WEST SUSSEX COUNTY COUNCIL CONSULTATION

TO:	Arun District Council FAO: Michael Eastham
FROM:	Stephen Gee Highways, WSCC
DATE:	27/11/18
LOCATION:	Land east of, Tye Lane, Walberton
SUBJECT:	WA/99/18/DOC Application for approval of details reserved by conditions imposed on planning reference WA/44/17/OUT relating to conditions 5, 9, 10, 11, 12 13, 16, 17, 24, 25, 27, 28, 30, 32, 33, 36, 41, 42 and 43.
DATE OF SITE VISIT:	
RECOMMENDATION:	☐ Advice ☒ Objection ☐ Modification ☐ No Objection ☒ More Information ☐ Refusal
S106 CONTRIBUTION TOTAL:	£ See below for breakdown.

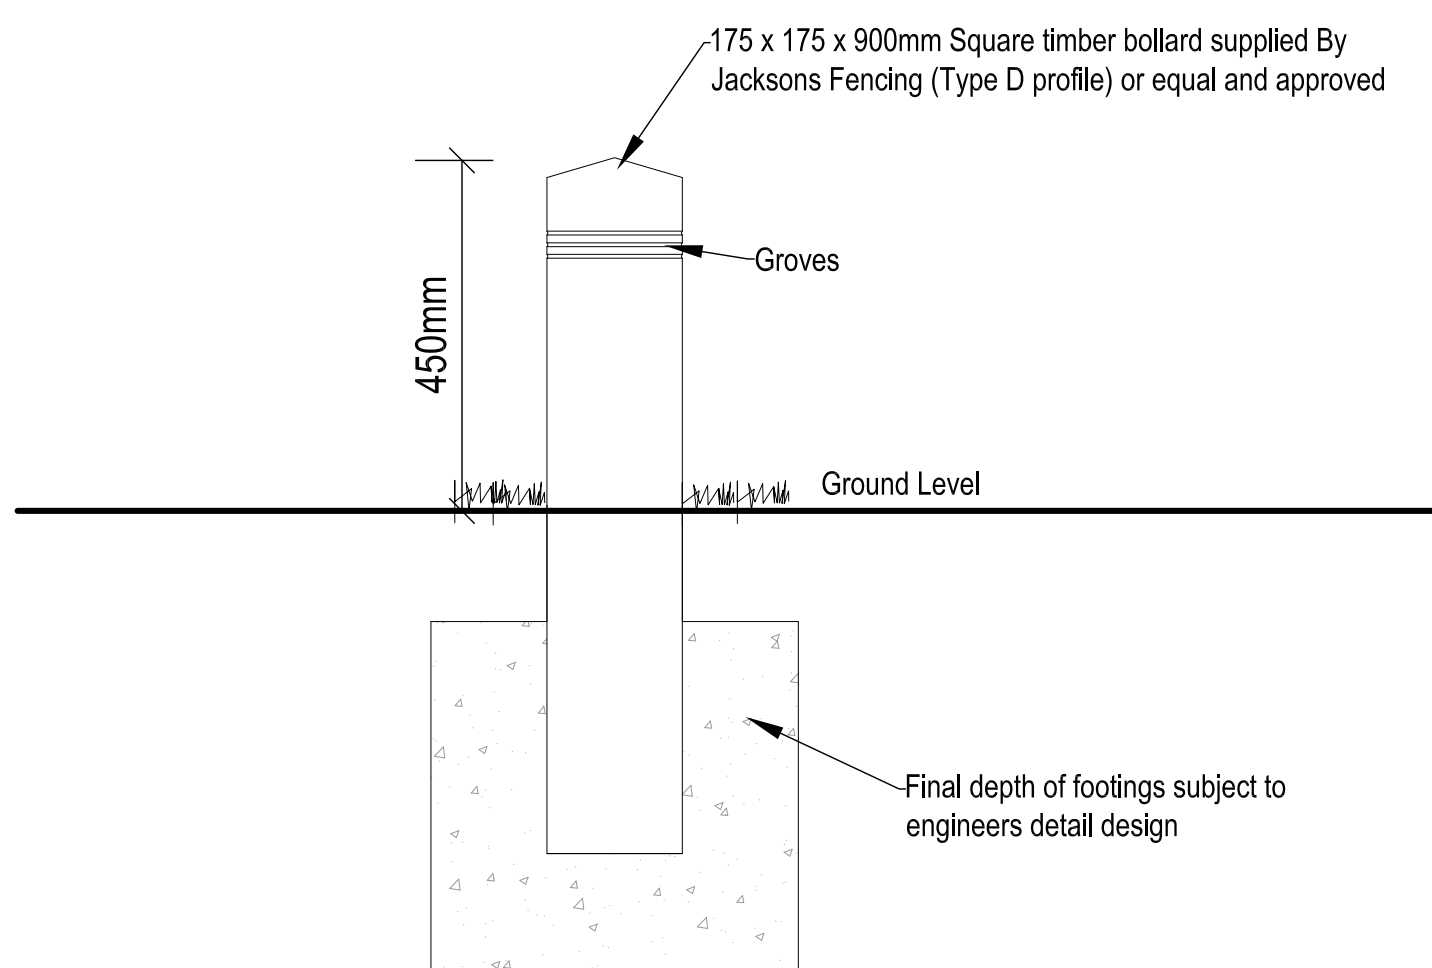
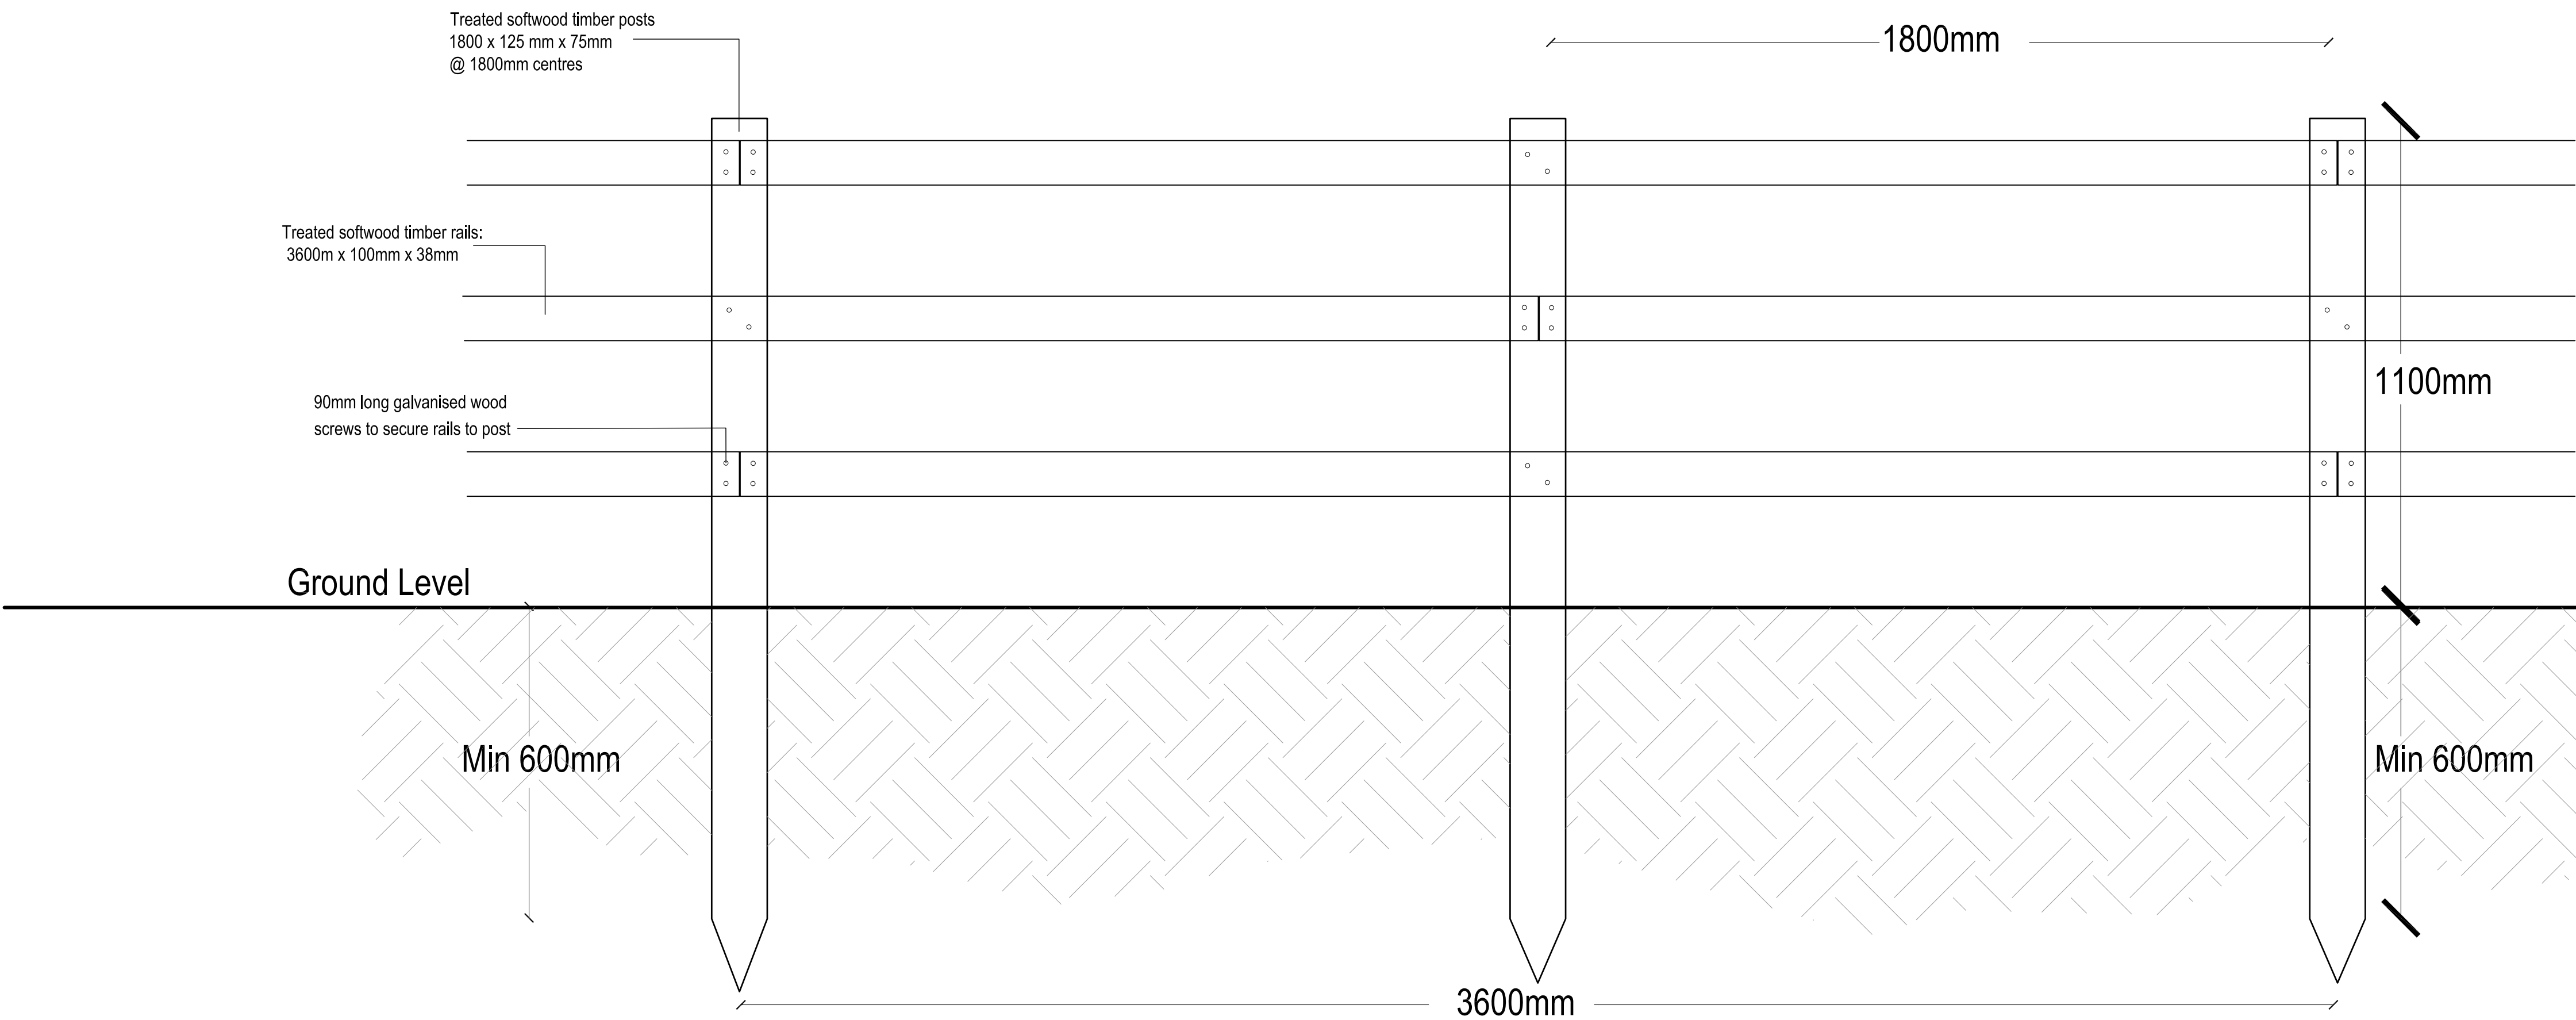
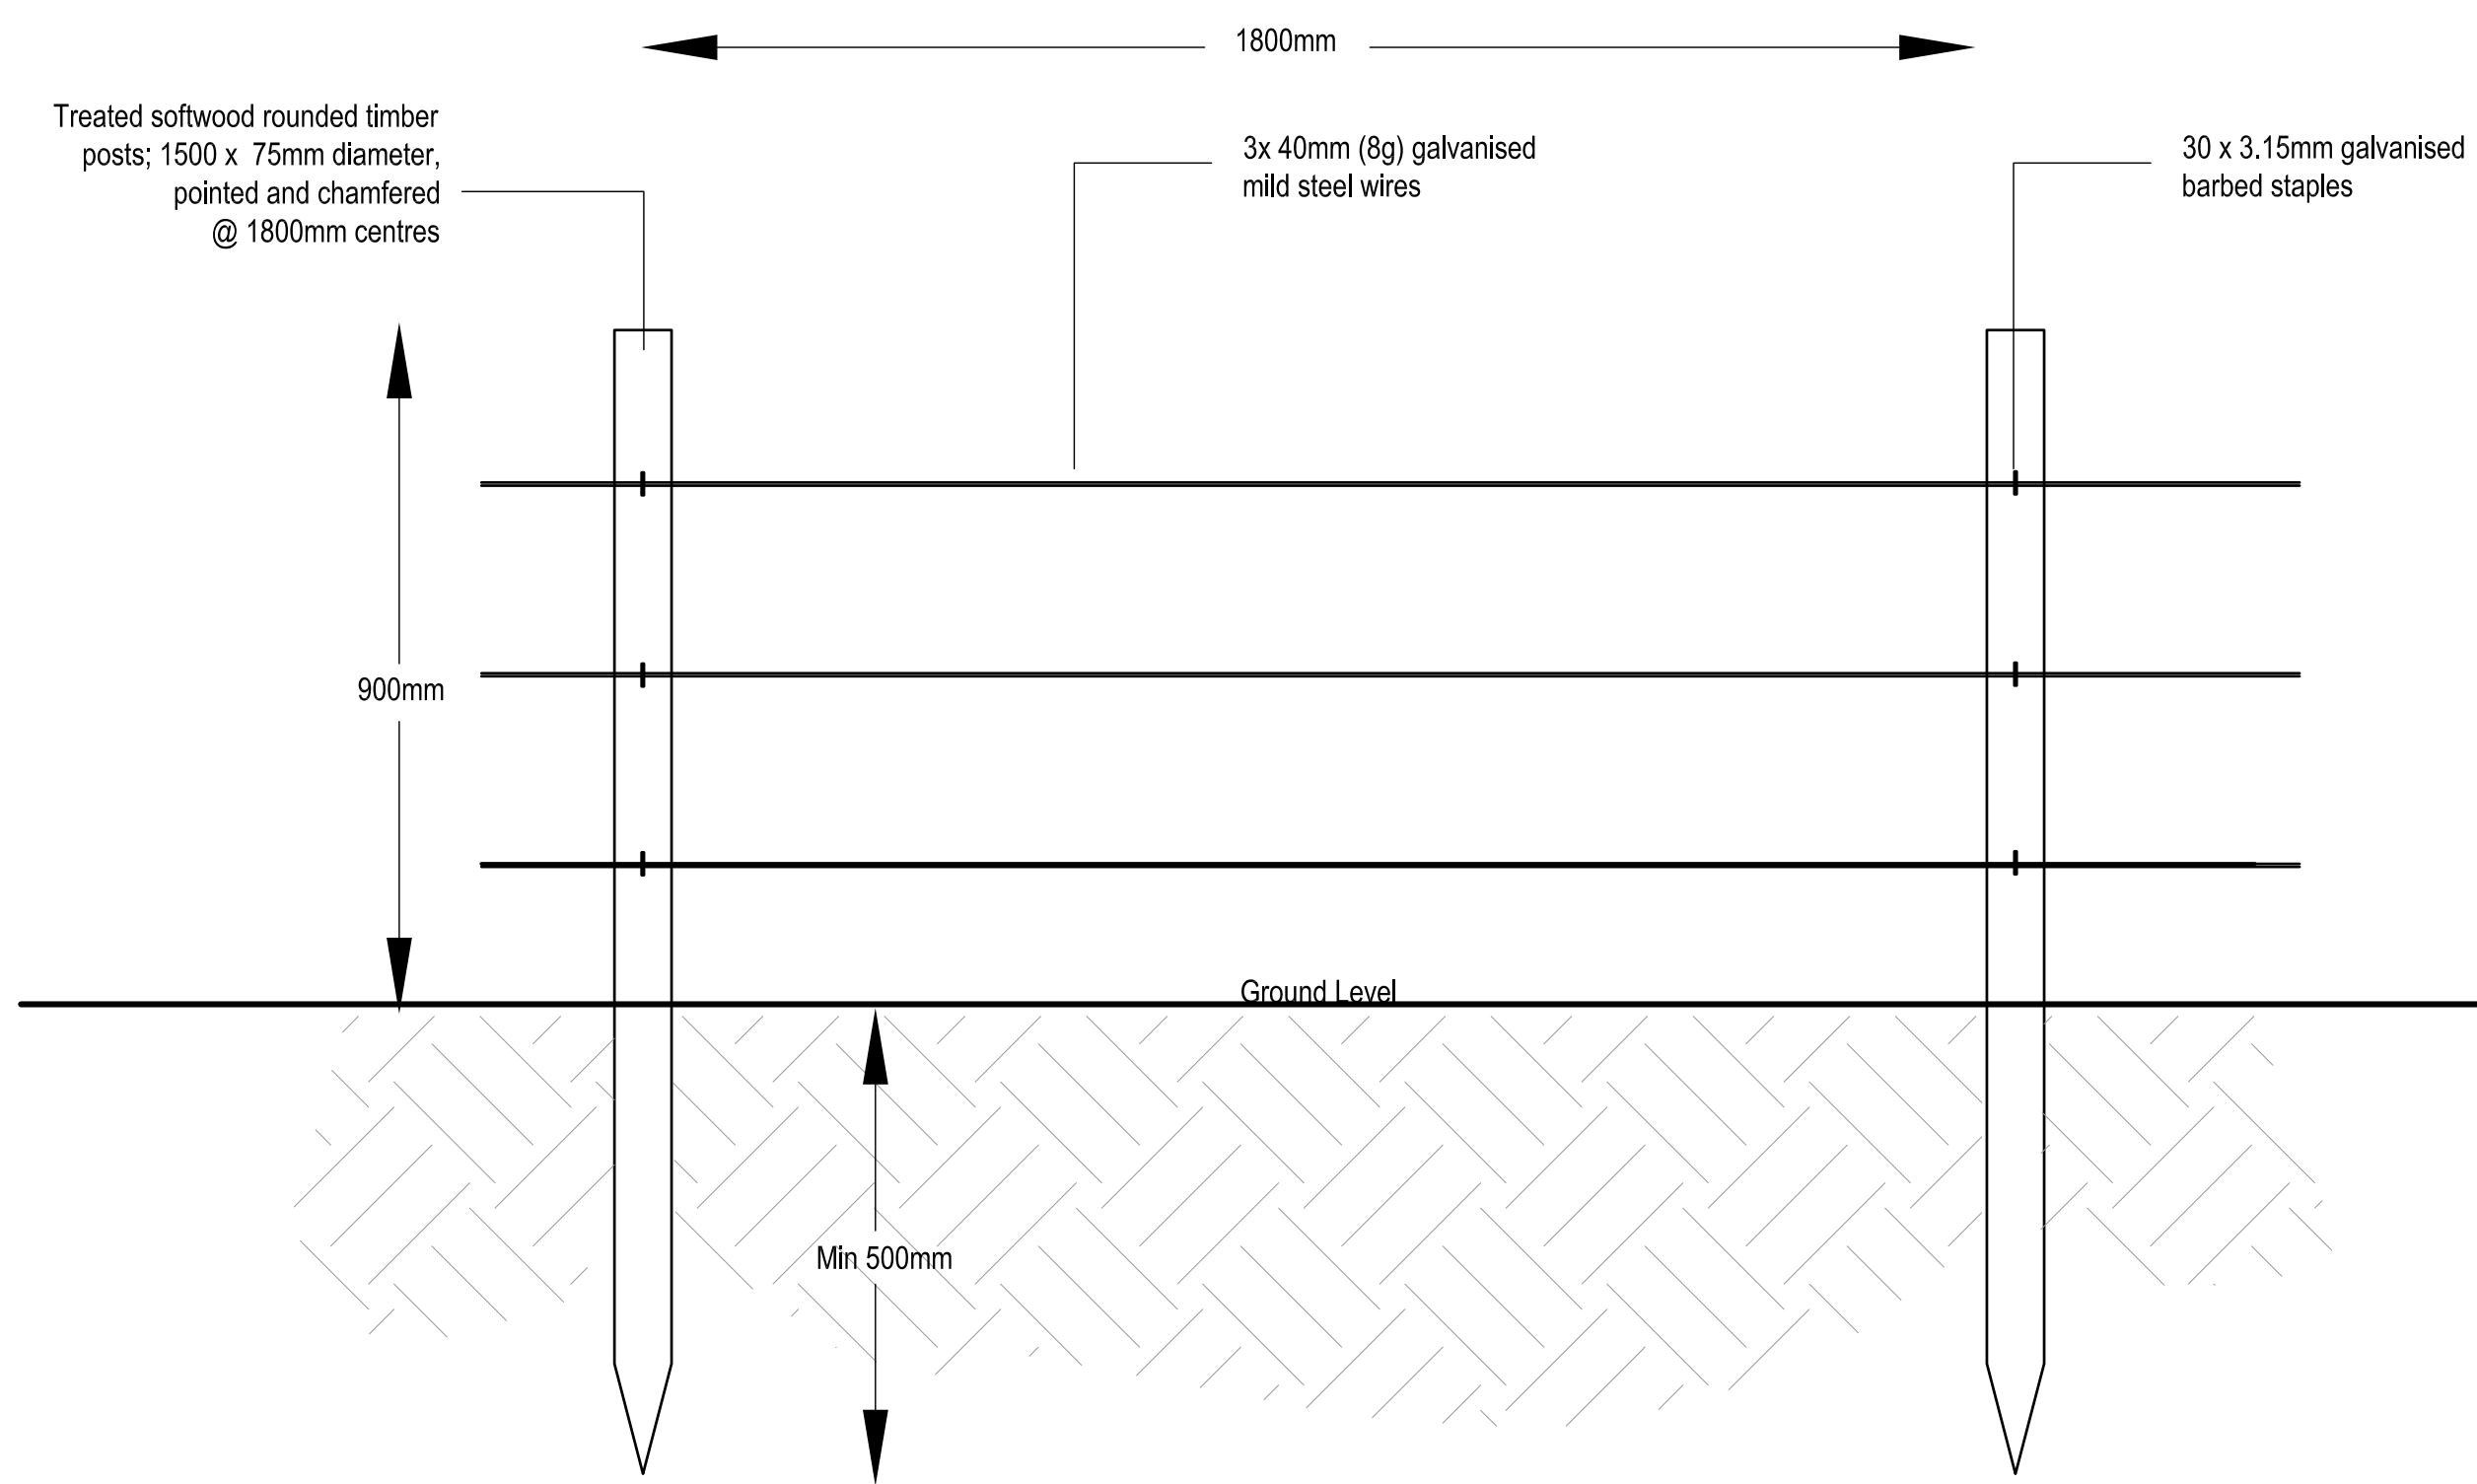
An objection is raised. The swept path plan provided appear to show an overhang at the northern drives, when comparing this to the public open space landscape proposals it appears to show the overhang area would have timber bollards of 900mm high placed within the area.

Additional close up detail of the tracking should be provided to confirm if this is not the case, or if so the landscaping proposals amended to allow a refuse vehicle to overhang.
